HIGHWAYS TECHNICAL NOTE

Plot 2, Carlton Industrial Estate, Industry Road, Carlton

24663-DR-C-0100

The Highways Technical Note has been produced by Dart Engineers to outline responses to the Highway Authority comments used relating to Planning Application Reference 2024/0668 for the site below:

Drawing
Title:
PLANS

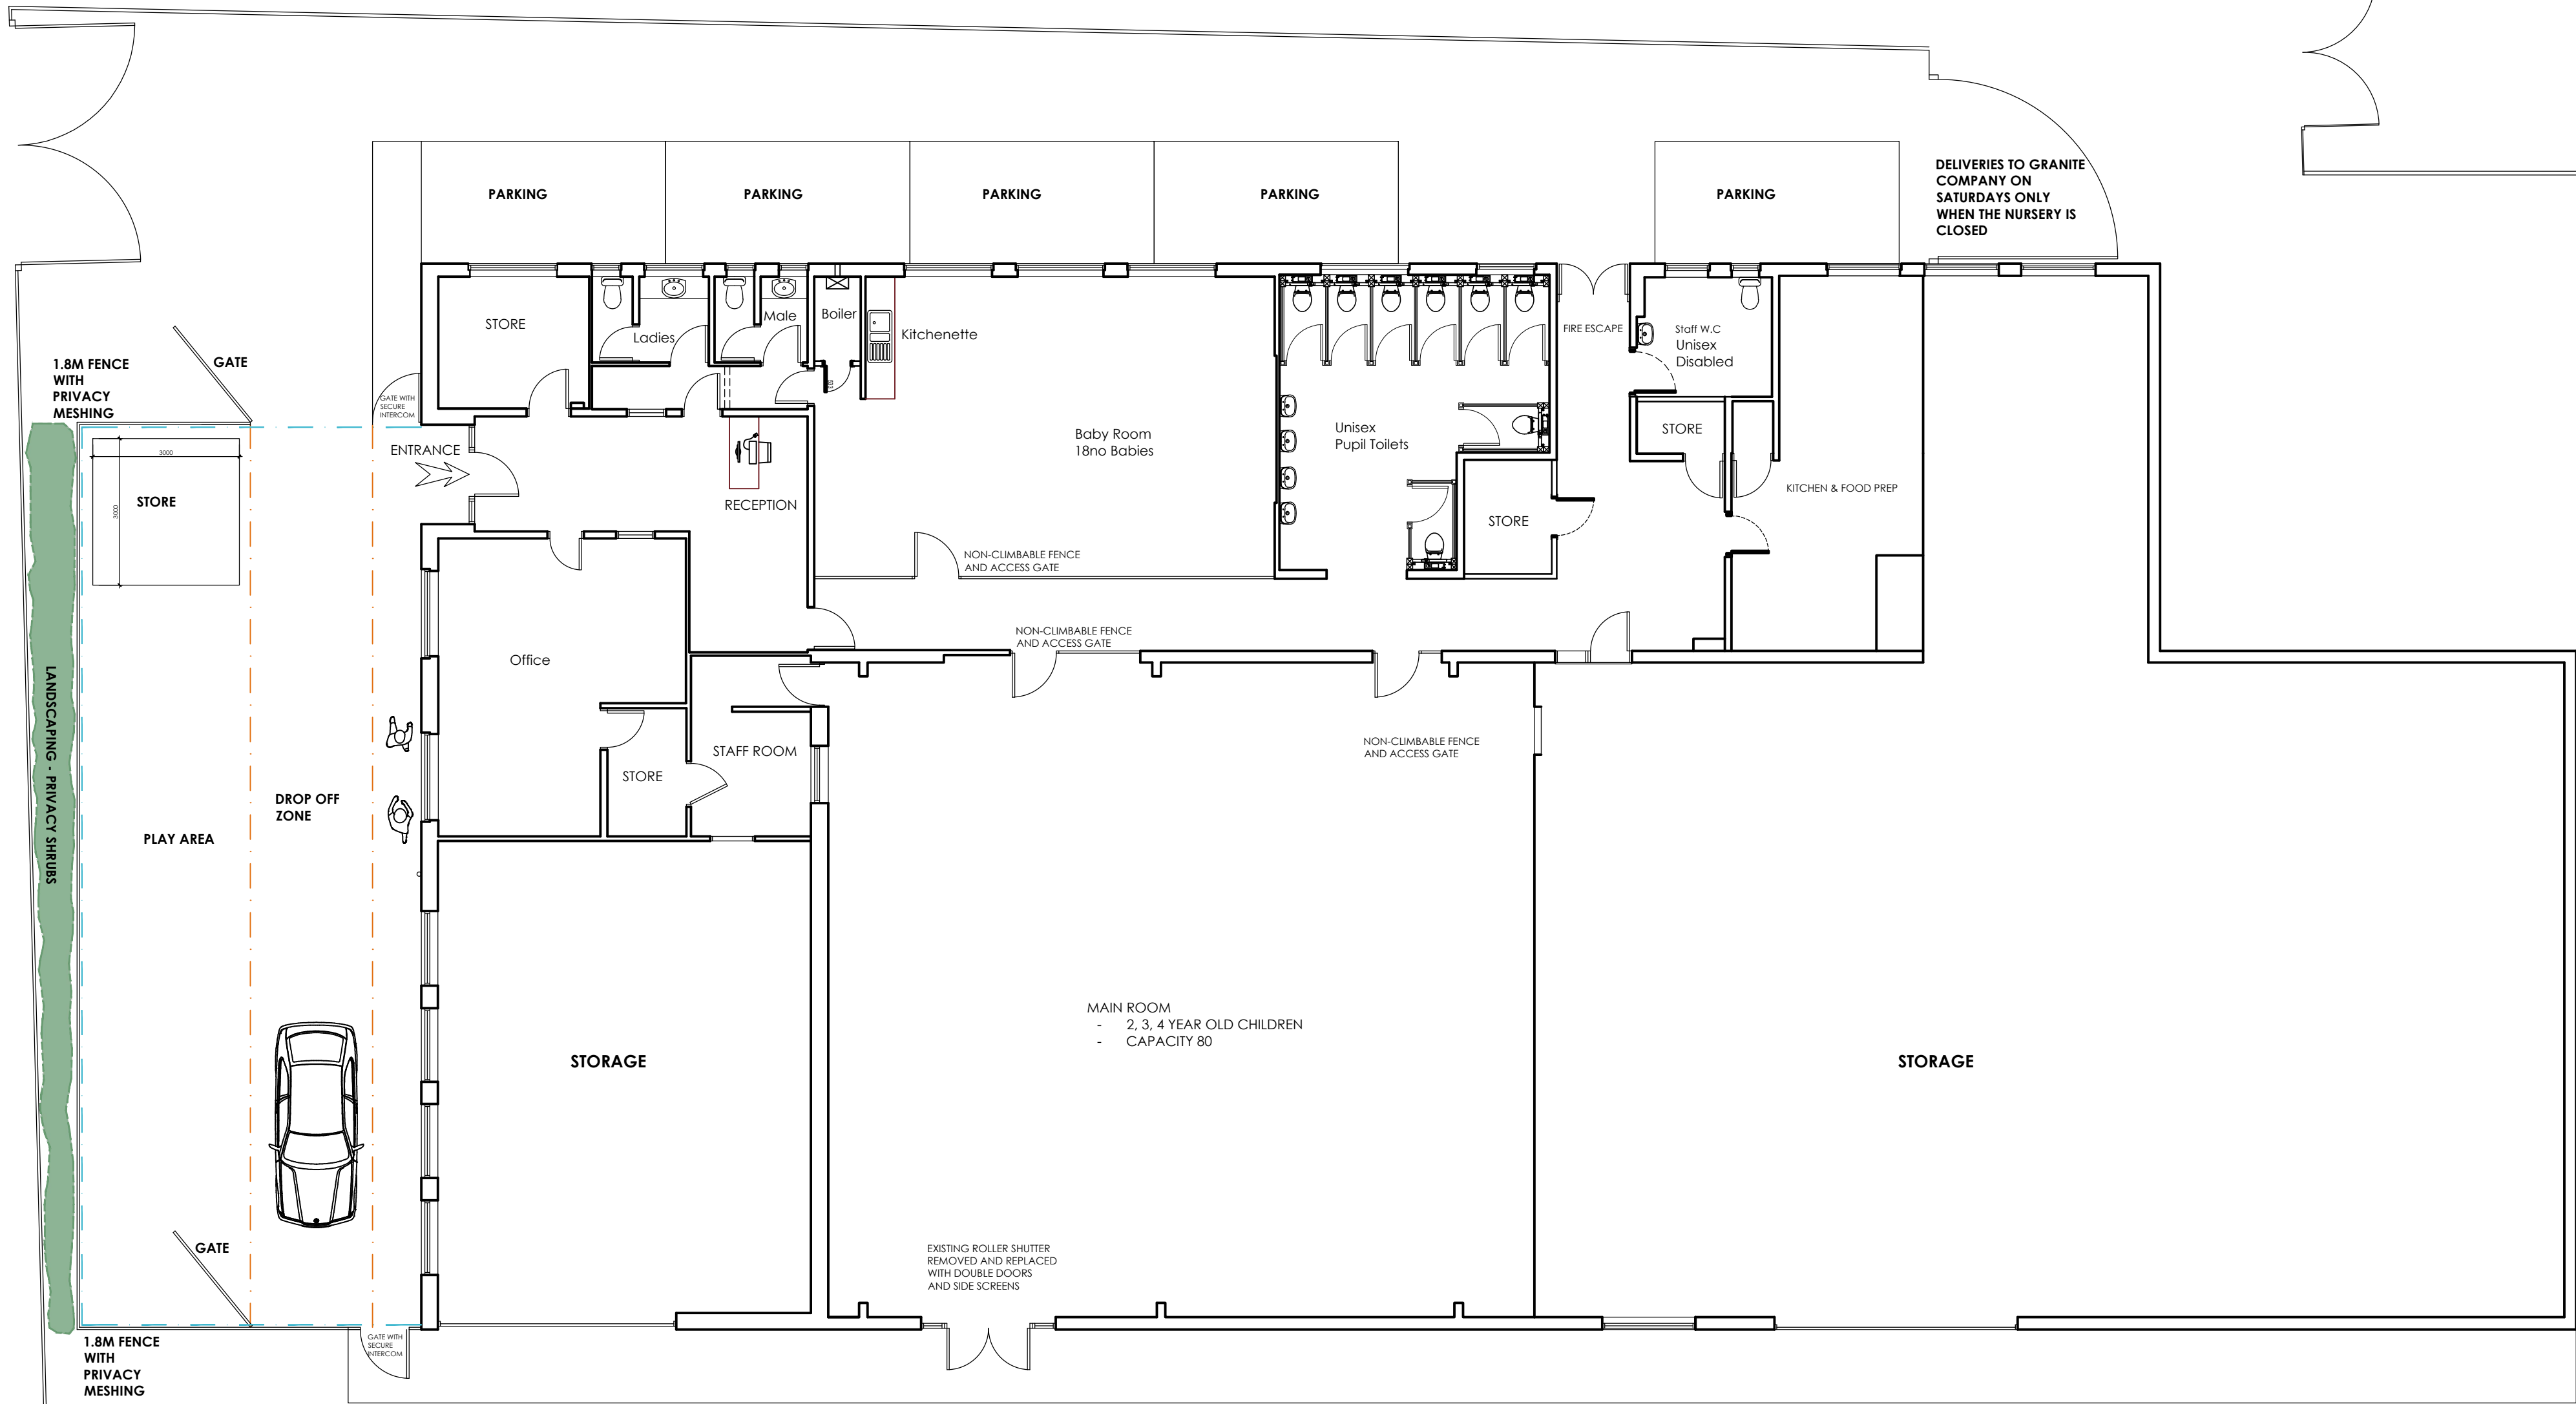
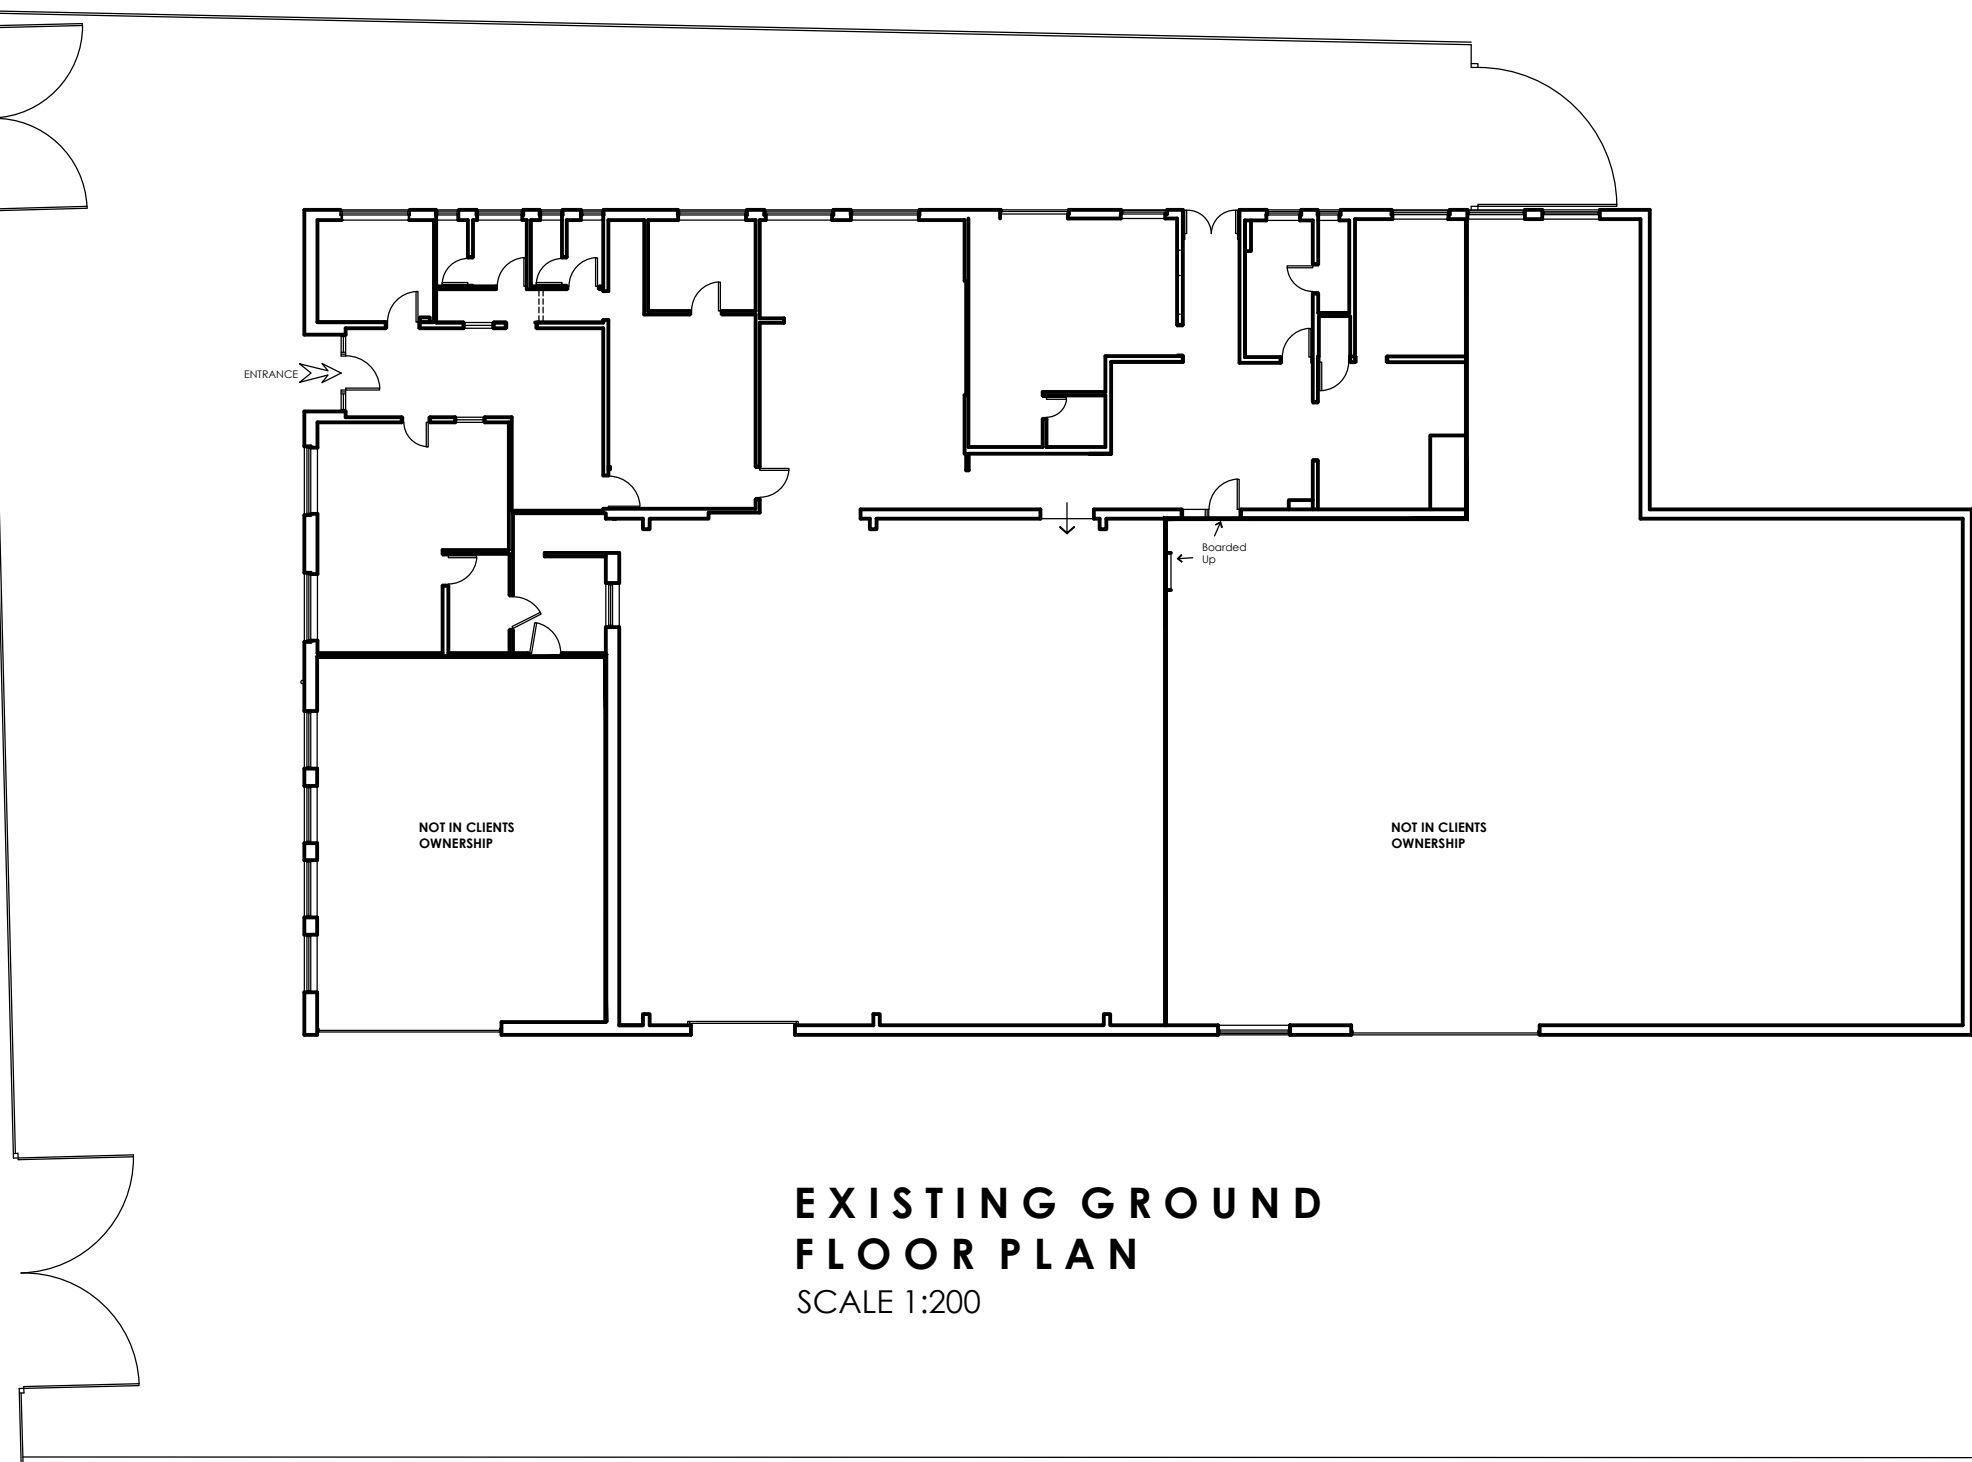
The site layout indicates a proposed in/out arrangement, with access at the upper end of the site and egress at the lower end. While this type of configuration is not uncommon, it can be challenging to enforce in practice. Additionally, the capacity of the proposed access arrangements appears insufficient to accommodate the volume of vehicles expected during peak drop-off and pick-up times.

Nursery drop-off and pick-up routines typically take time, especially during pick-up periods when parents or guardians often receive a summary of their child's day. With limited stacking space on-site, there is a significant risk of vehicles queuing along the site access road. This issue is further compounded by the proximity of the site to the junction of Industry Road and Carlton Road, where queuing vehicles could disrupt the free flow of traffic on the surrounding highway network.

It is accepted that the arrangement is not uncommon for the proposed use of the unit. The arrangement has capacity internally within site for 6-7 no. vehicles without impacting the adopted highway. As this will be a managed and monitored arrangement it is anticipated that this will be adequate and flow of vehicles will be maintained to ensure flow of traffic.
